**Canal &
River Trust**

Your Ref 2026/90889

Proposal: Discharge of details reserved by conditions 5 (Building Recording), 6 (Demolition Method Statement), 7 (Chimney Method Statement), 8 (New Walls and/or other structures Adjacent to the Listed Chimney) on previous permission 2025/91645

Location: Turnbridge Mills, Quay Street, Huddersfield

Section Through

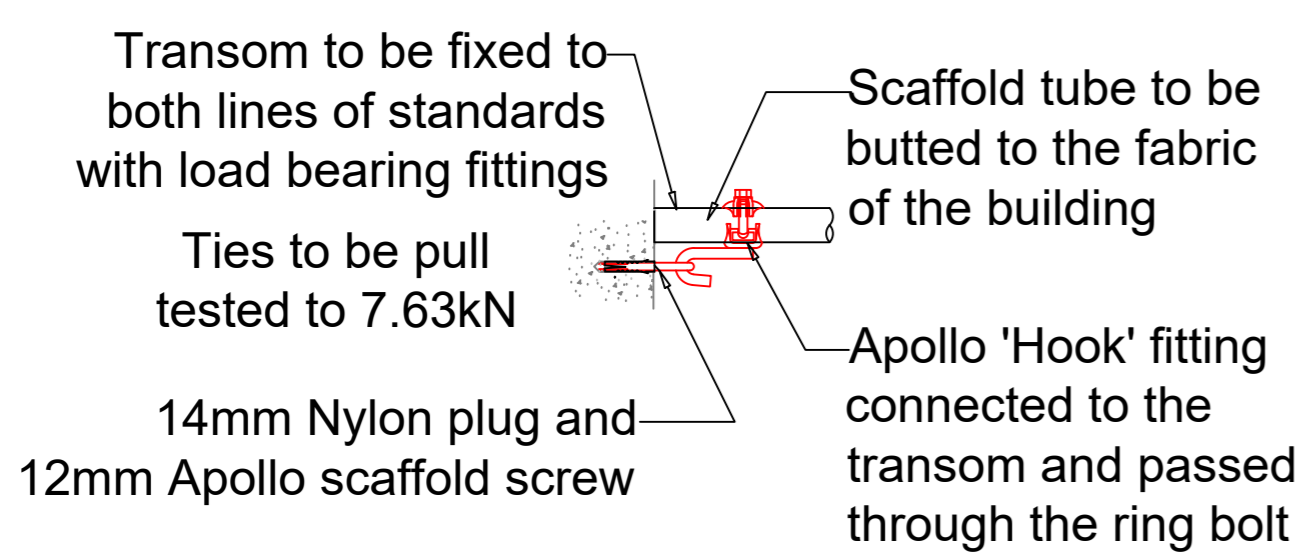
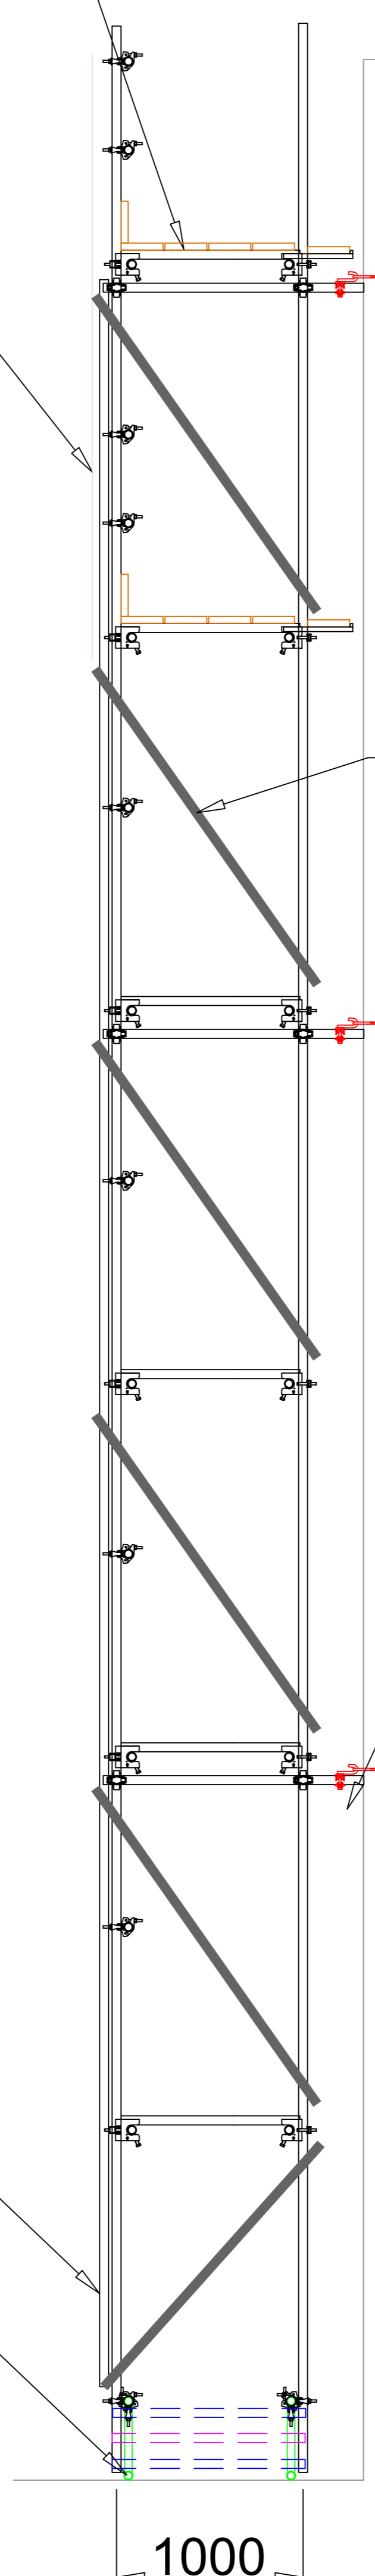
The scaffolding details provided indicate that scaffolding will oversail the canal. Debris netting is proposed. However, due to the proximity to waterspace, we do request that additional measures including the use of double boarded platforms and sheeting on the walkways for the scaffolding platforms should be specific in order to reduce the extent of small scale dust and debris that could otherwise reach the waterpace below.

We request that this detail should be specified in the submitted details prior to the commencement of demolition works on the building.

Methodology: demolition of the final three floors.

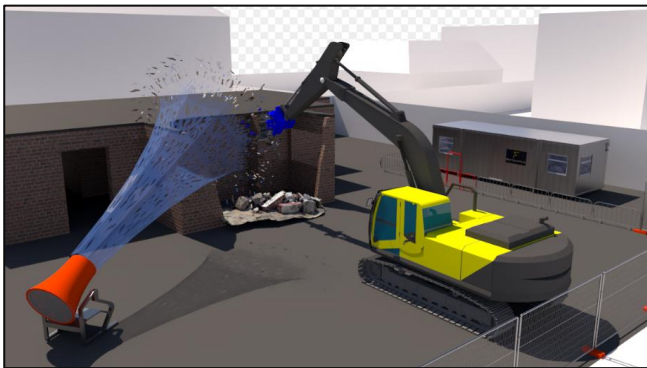
From a health and safety perspective, the Trust have concern that the methodology for the construction of Building B states that works will be “Starting at the furthest end from the canal side”, where “floors will be removed one bay at a time”. This indicates that the demolition activities will be working towards the canal elevation, with the possible risk of a free standing wall remaining above the canal on each floor as demolition progresses. The canal is publicly accessible space, with boats travelling below. We are therefore concerned that the sequencing could destabilise the remaining wall prior to its removal.

To safeguard users of the canal below, we request that the demolition works should specify the use of breakers and more controlled methods to limit the potential for any large scale collapse of the freestanding structure as it is taken down. We request that details of this should be provided prior to the discharge of this condition.
